DESIGNER'S RESPONSE

Road Safety Audit Stage 1

Crossley Lane, Dalton, Kirklees - Road Safety Audit Stage 1

2021-10 Dalton RSA1 – Revision 0

Proposed Traffic Calming Scheme

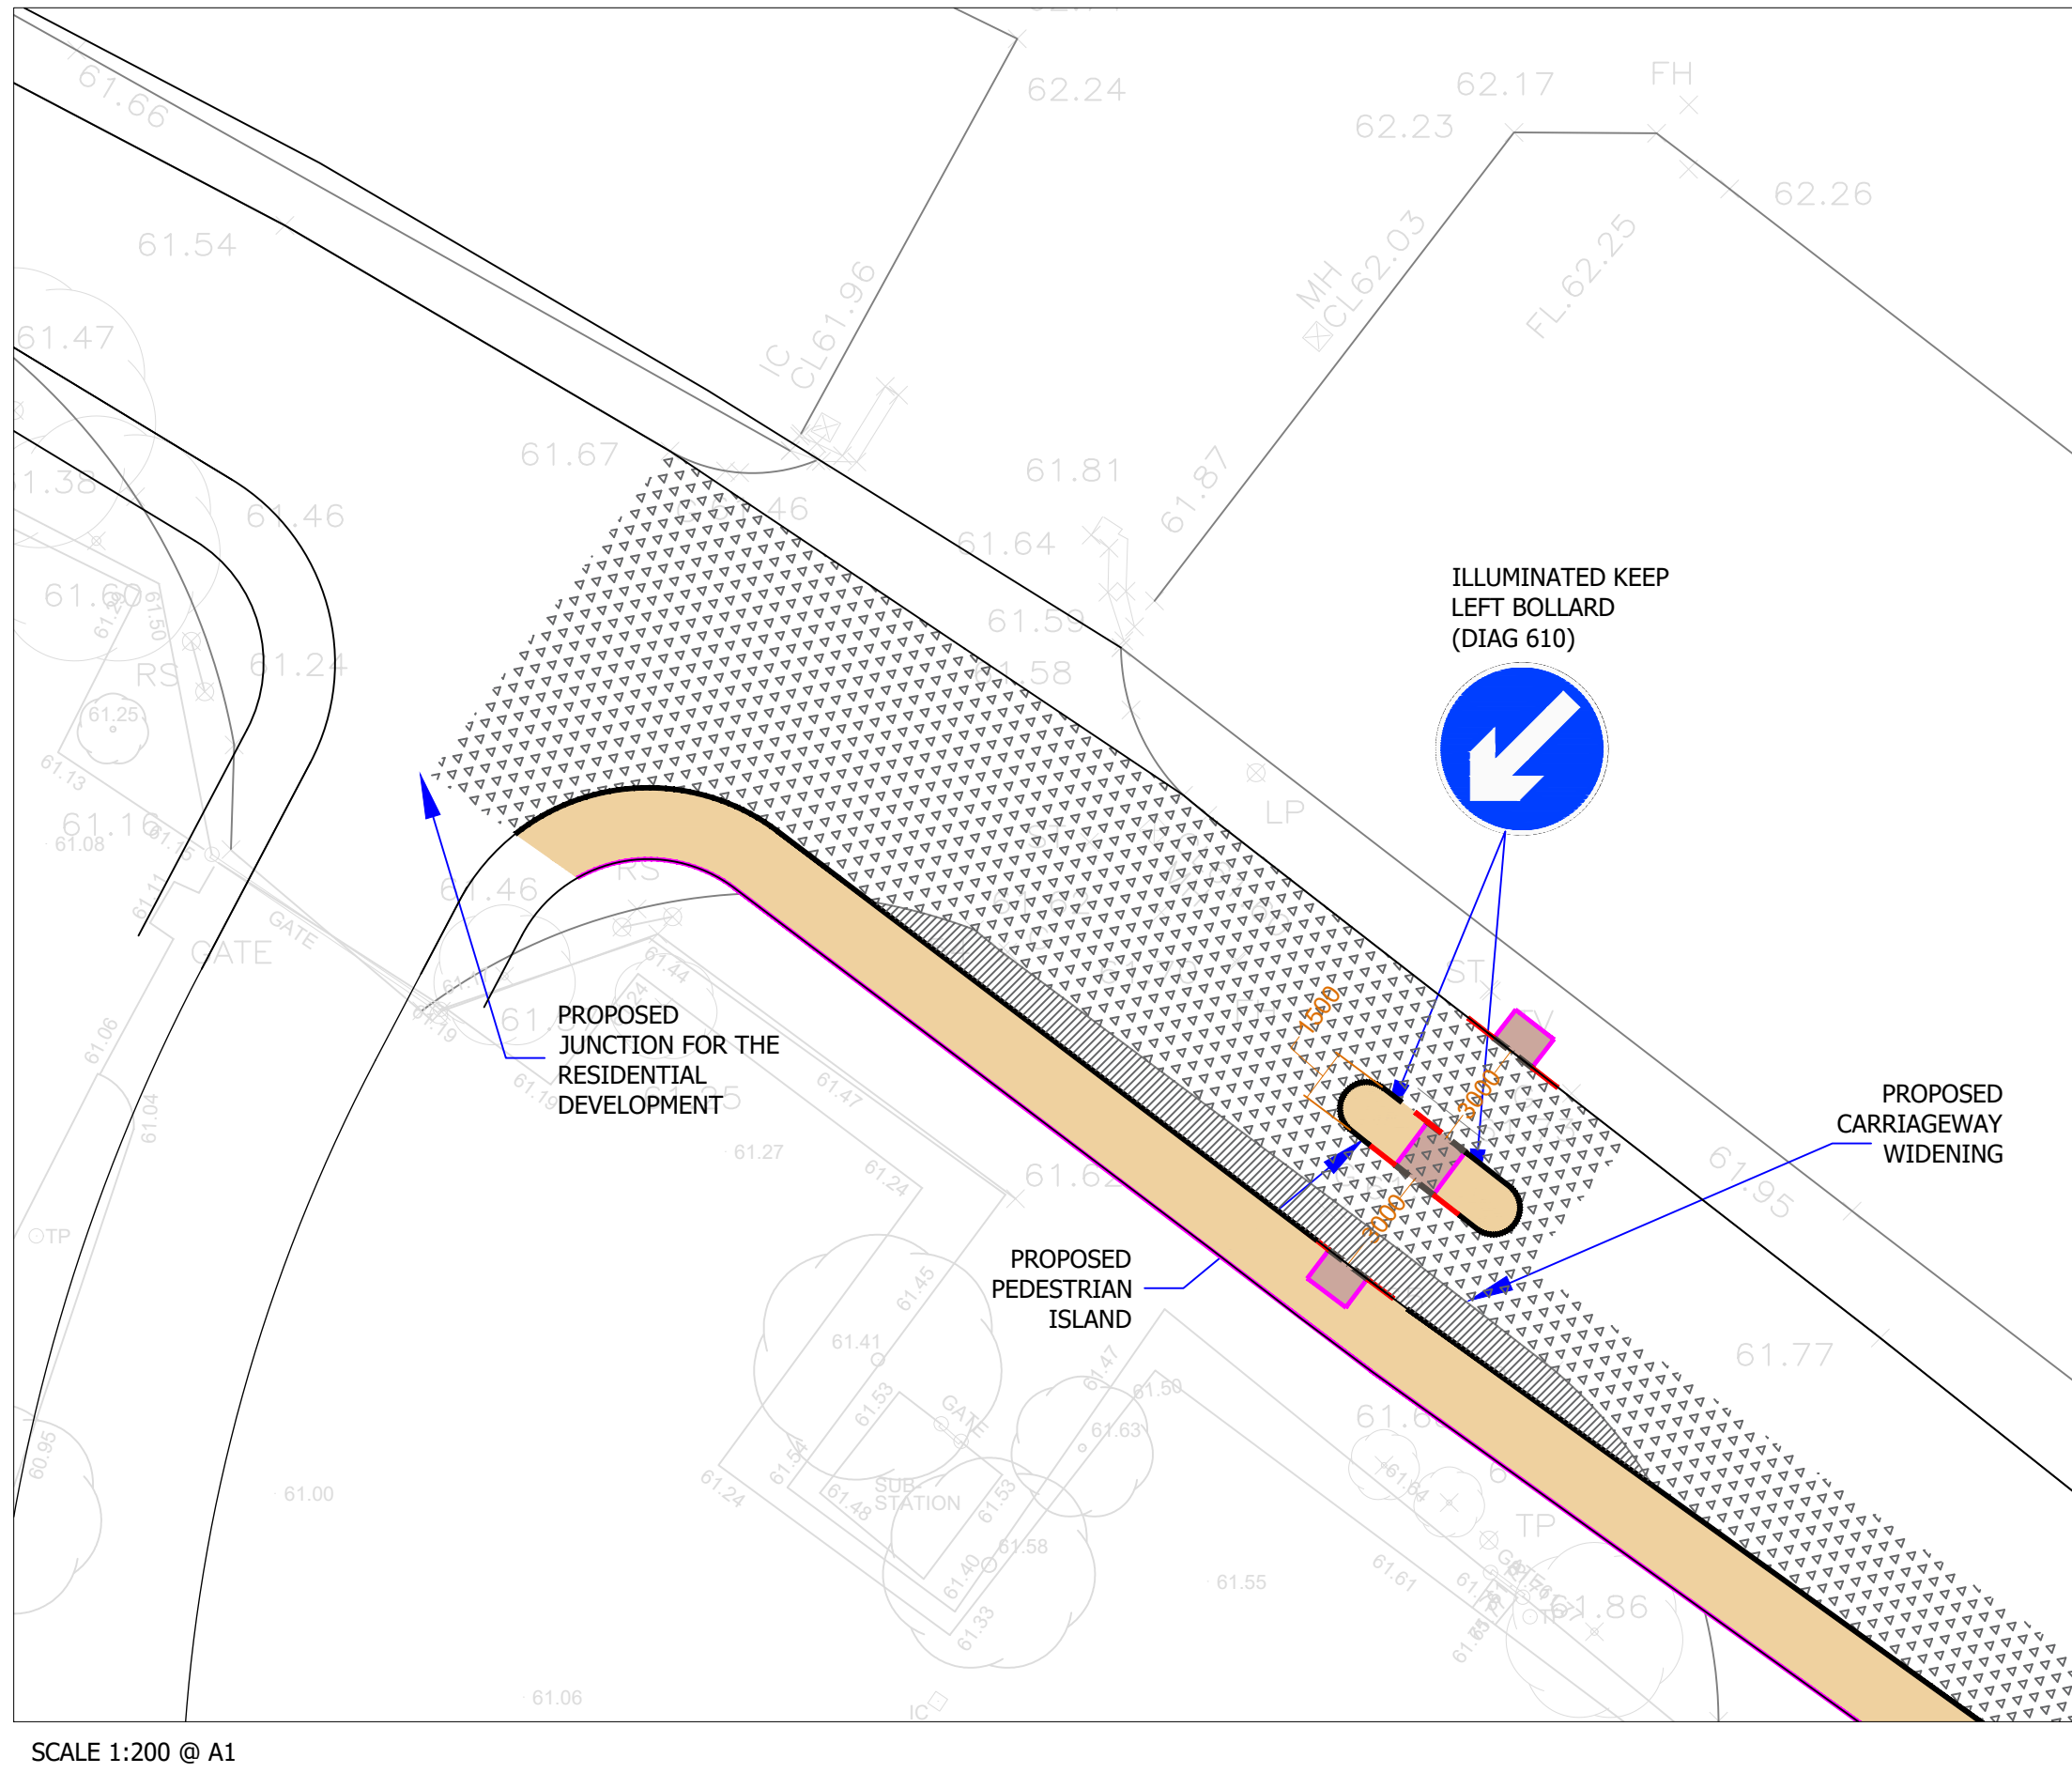
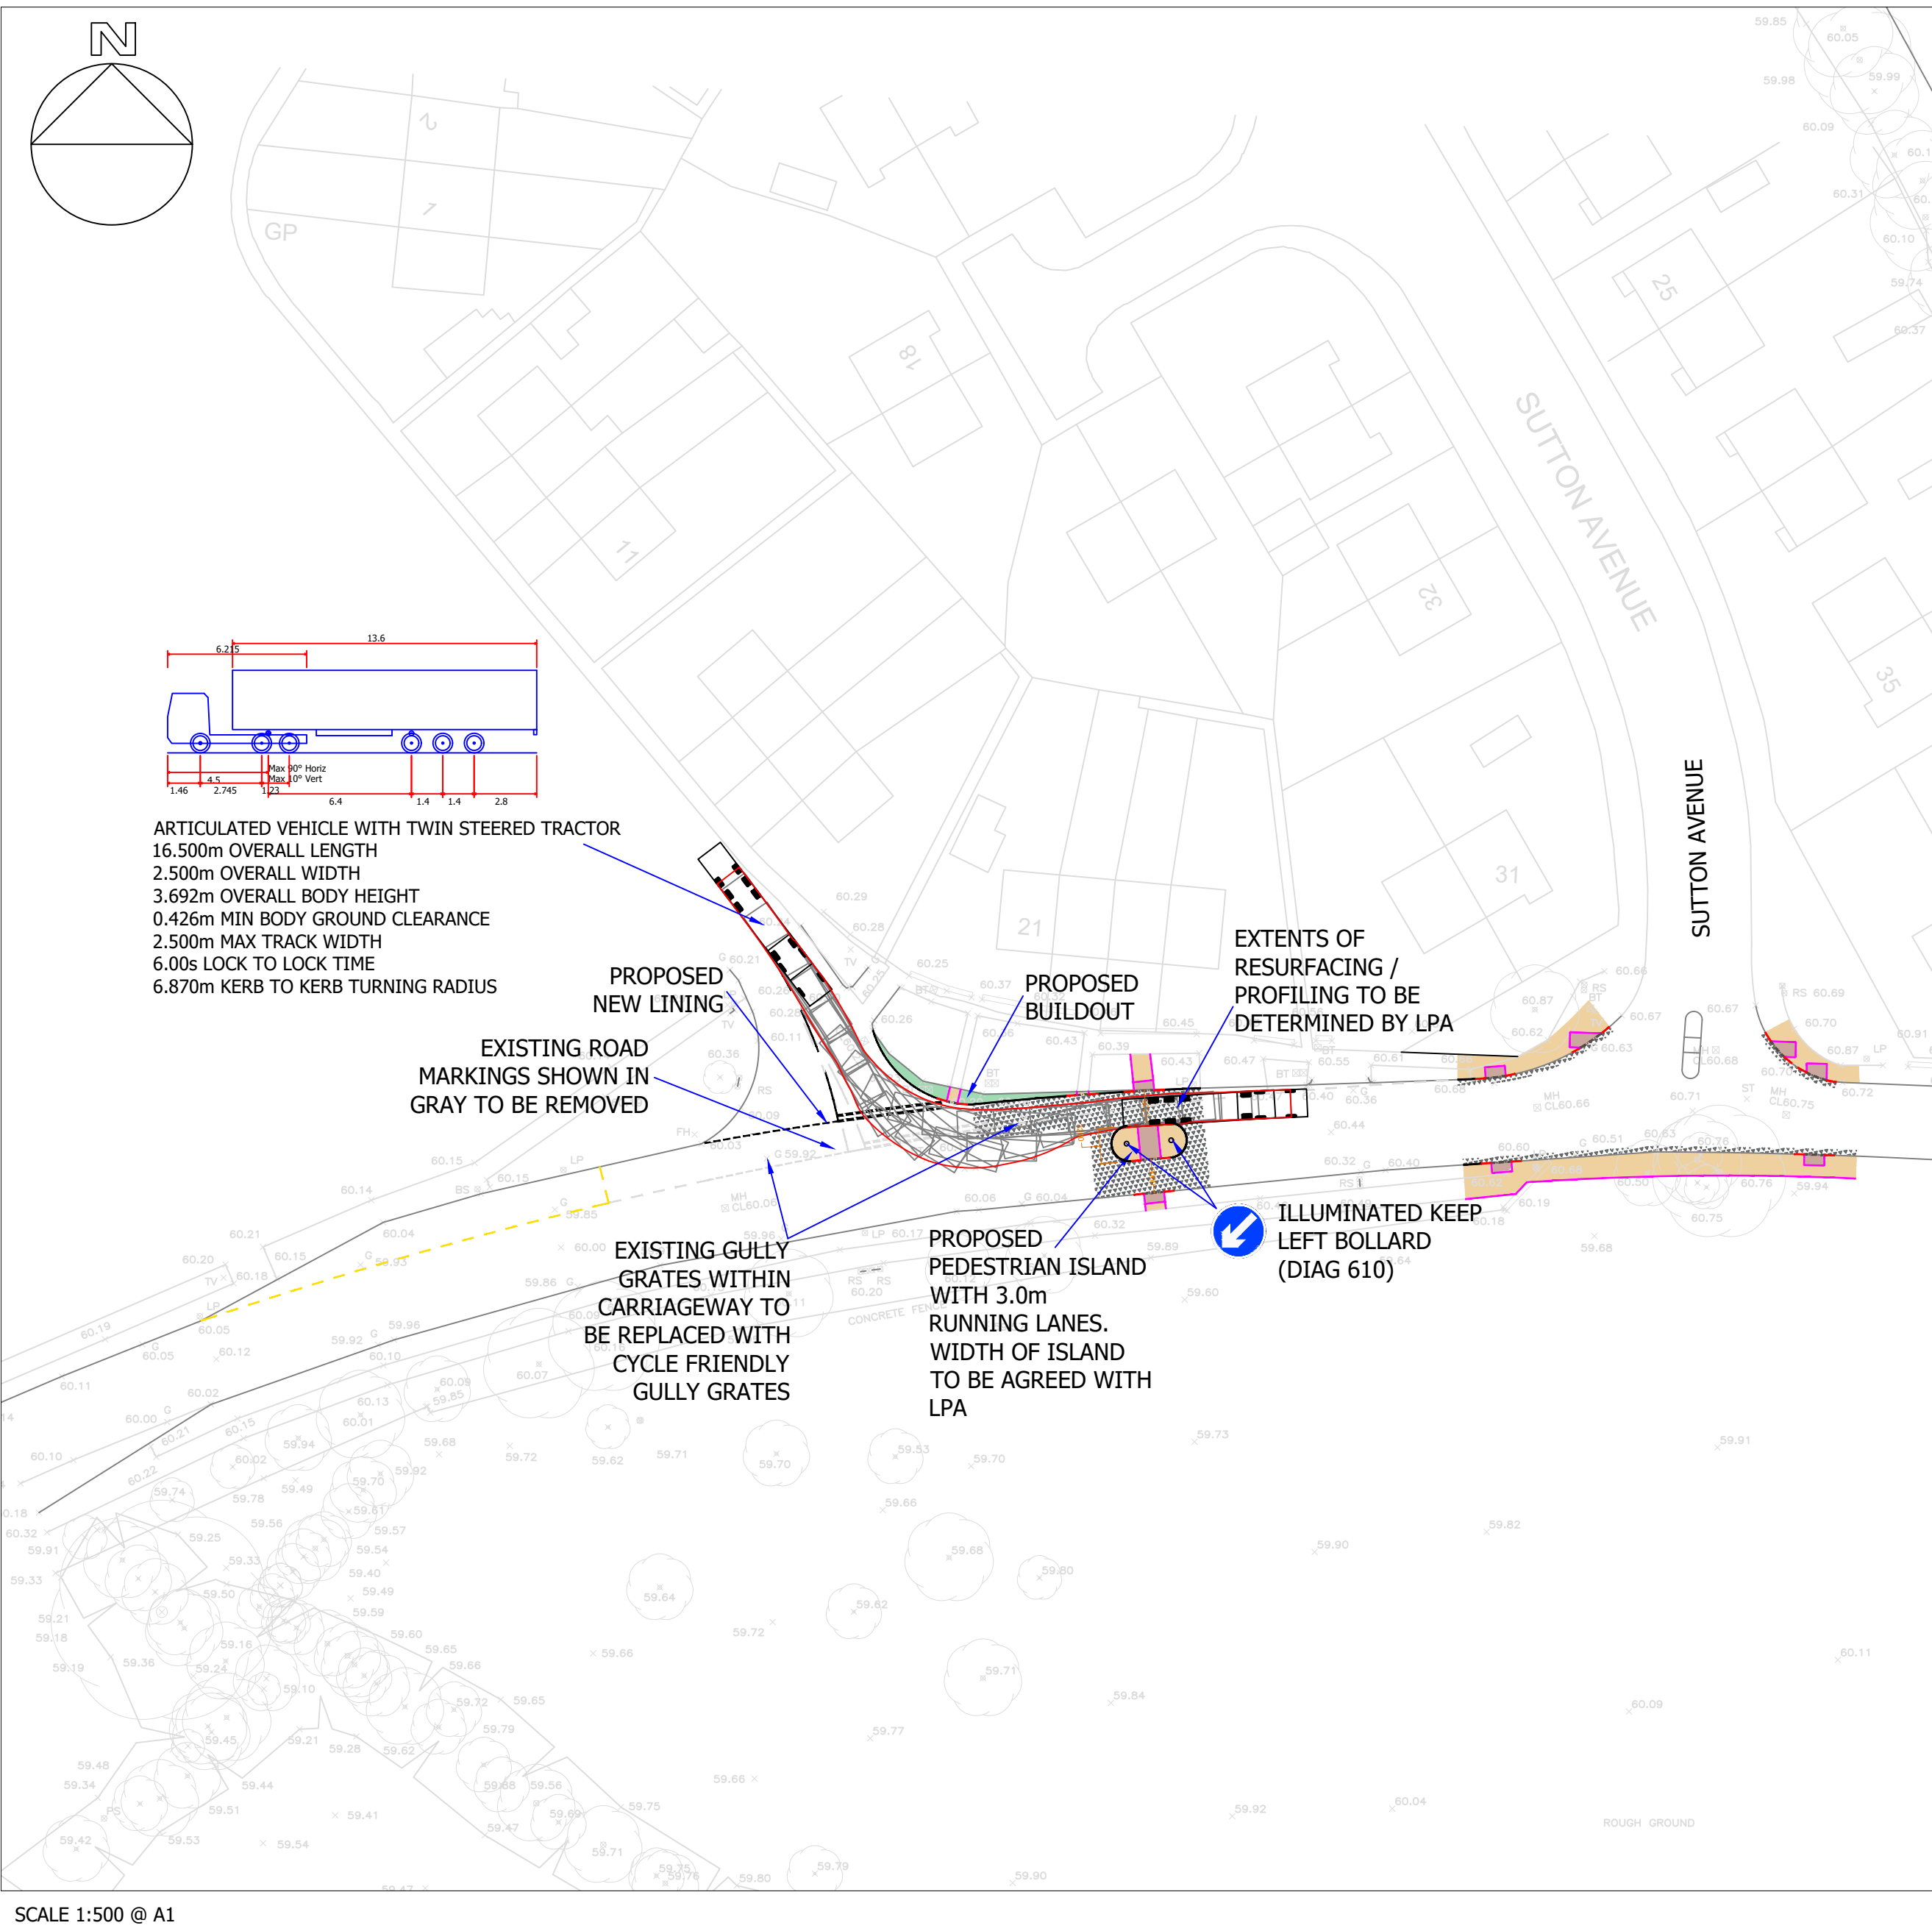
Standard junction visibility distances from MfS have been indicated on the drawings for all access points on the existing road network, there is a concern especially on Crossley Lane that a basic assumption of 30mph may not be appropriate and that vehicle speeds are likely to be in excess of this. This assumption may increase the risk of junction related collisions related to insufficient junction visibility.

It is recommended that speed surveys are completed on Crossley Lane to inform the next stage of design in terms of junction visibility requirements.

Not Accepted – as part of the development it is proposed to provide a traffic scheme along Crossley Lane in the form of a raised junction, a speed table and speed cushions. The scheme should reduce speeds to an appropriate level at or below the current 30mph speed limit. A separate Stage 2 Road Safety Audit has been carried out for the proposed traffic calming scheme.
